## **Application by RWE Renewables UK Solar and Storage Limited for Peartree Hill Solar Farm (EN010157)**

### **The Examining Authority's (ExA's) written questions and requests for information (ExQ1)**

**Issued on 29 July 2025**

Coordinate System:

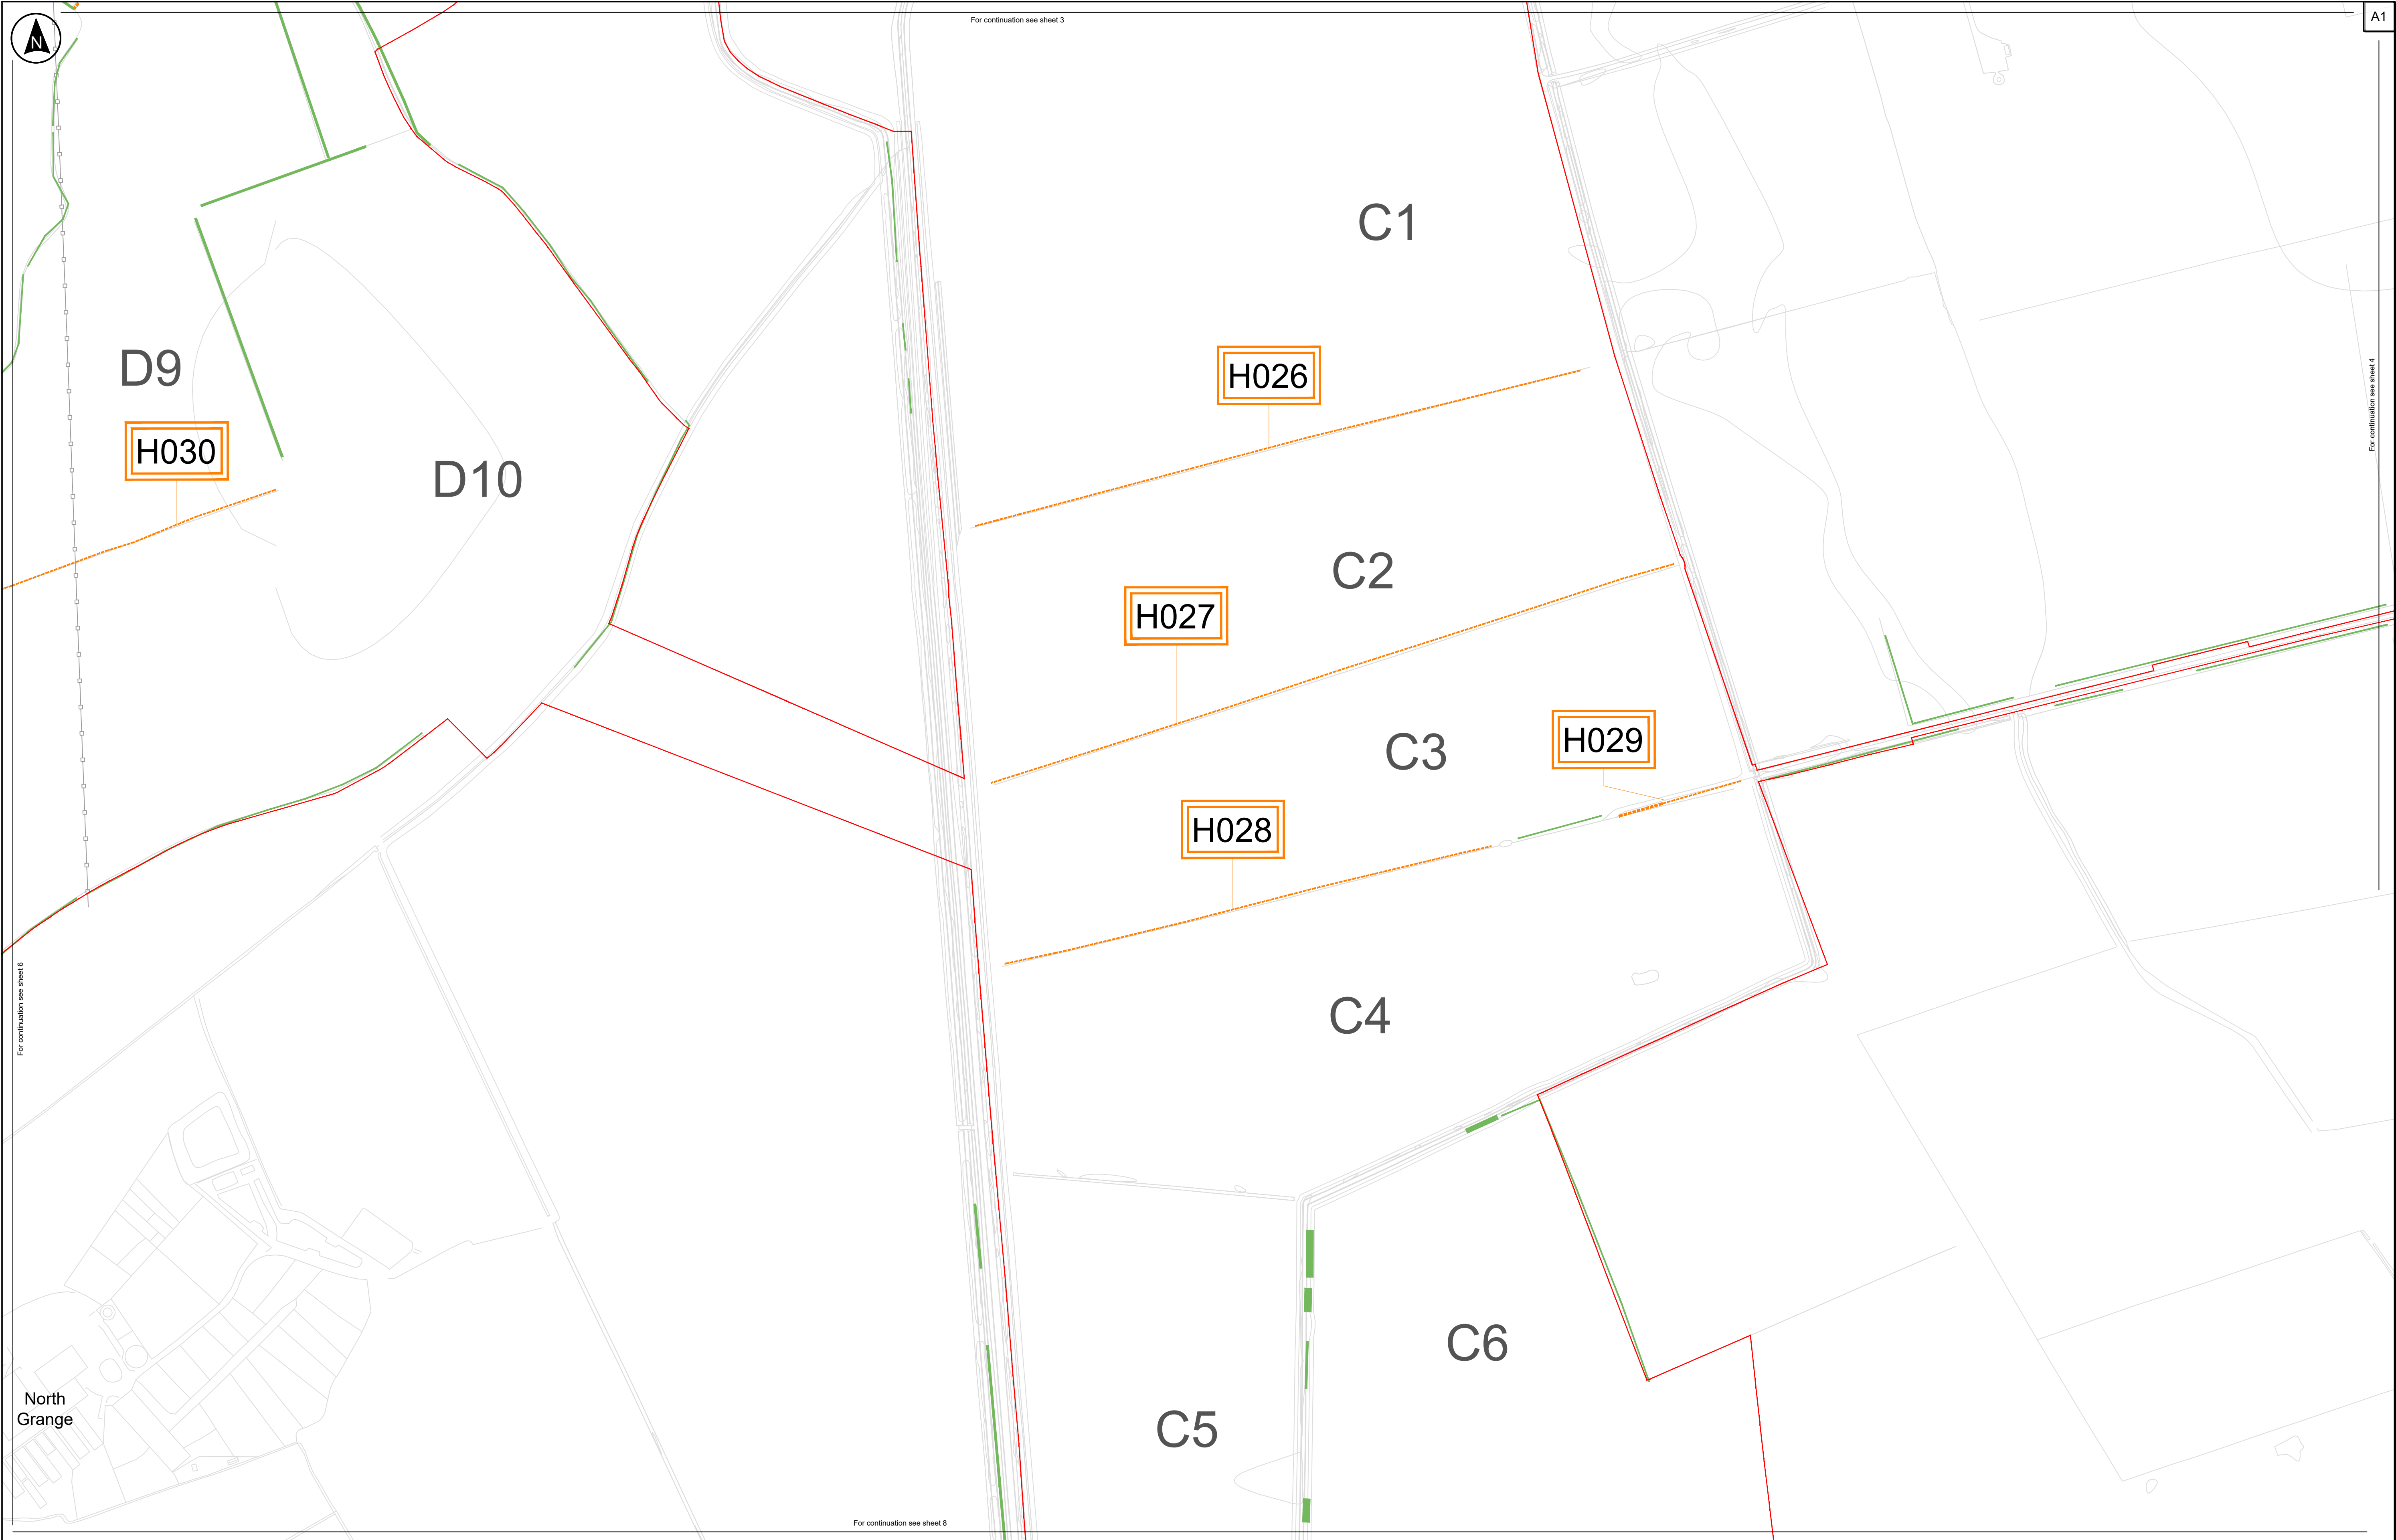
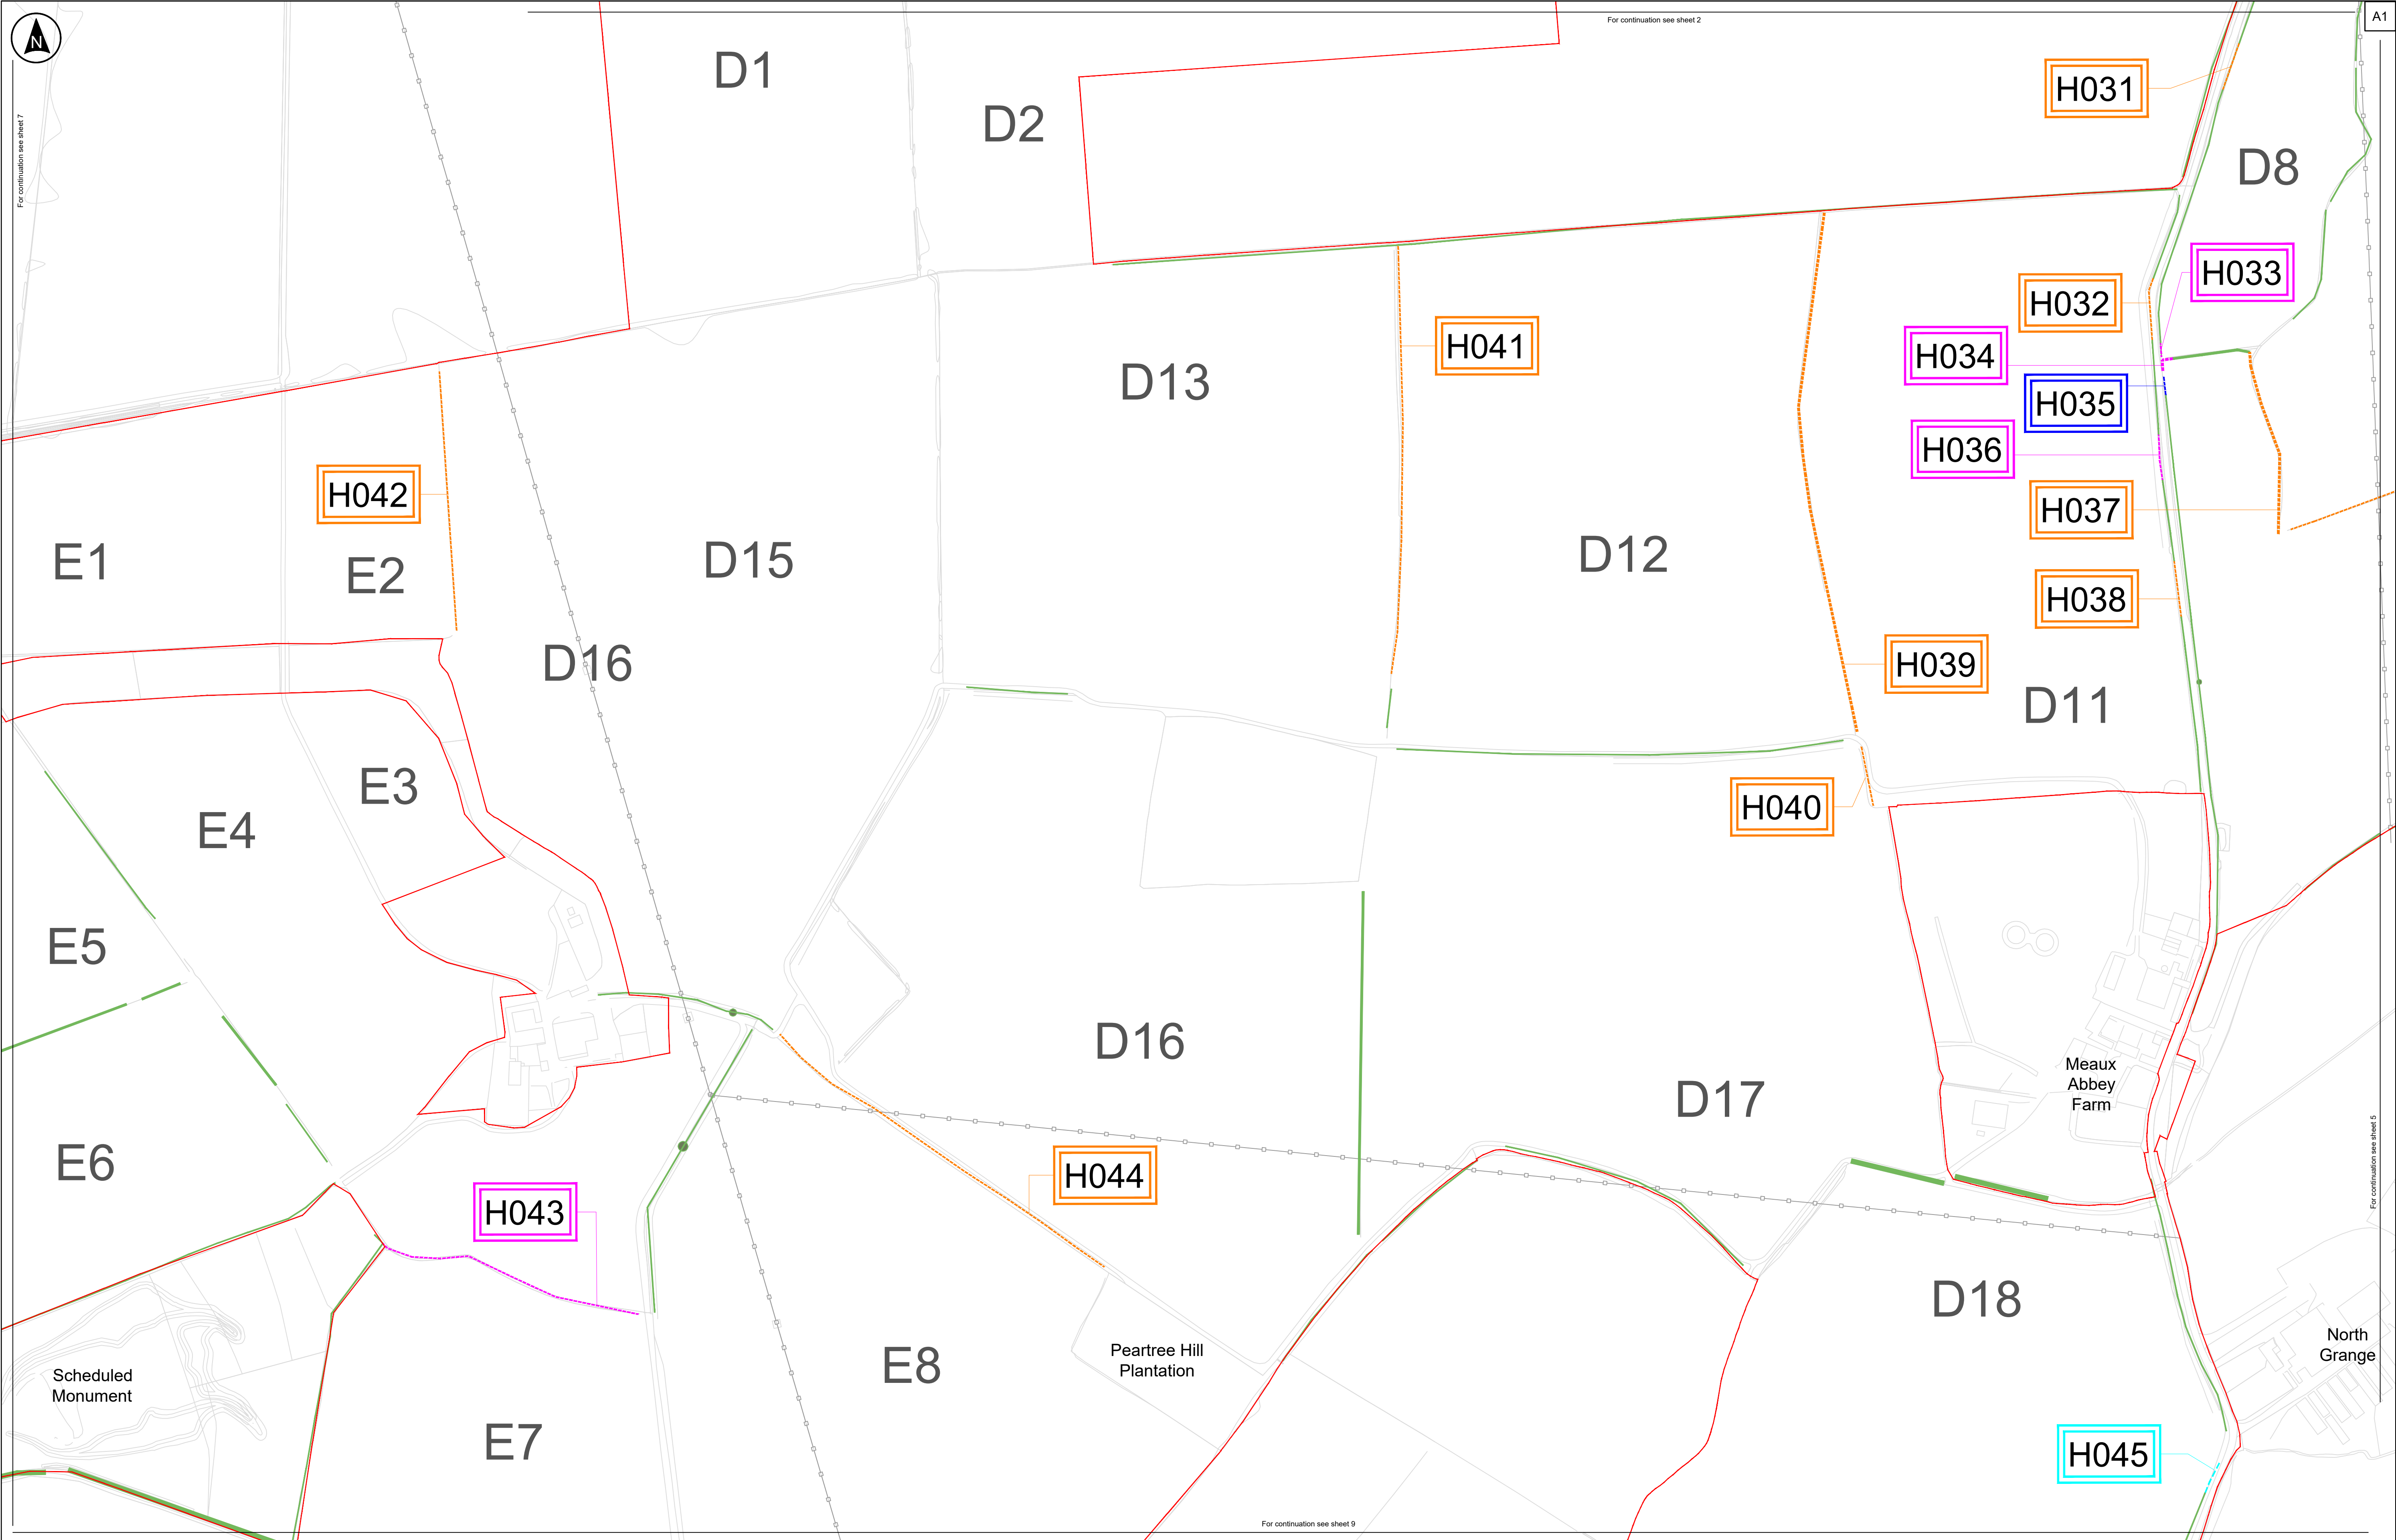
1.2.74	The applicant	Sch 13, Part 2 – some hedgerows appear to be incorrectly numbered with an additional zero (including H0014, H0015, H0016, H0024 and H0043) when compared with the relevant plan [PDA-007]. Please address as necessary
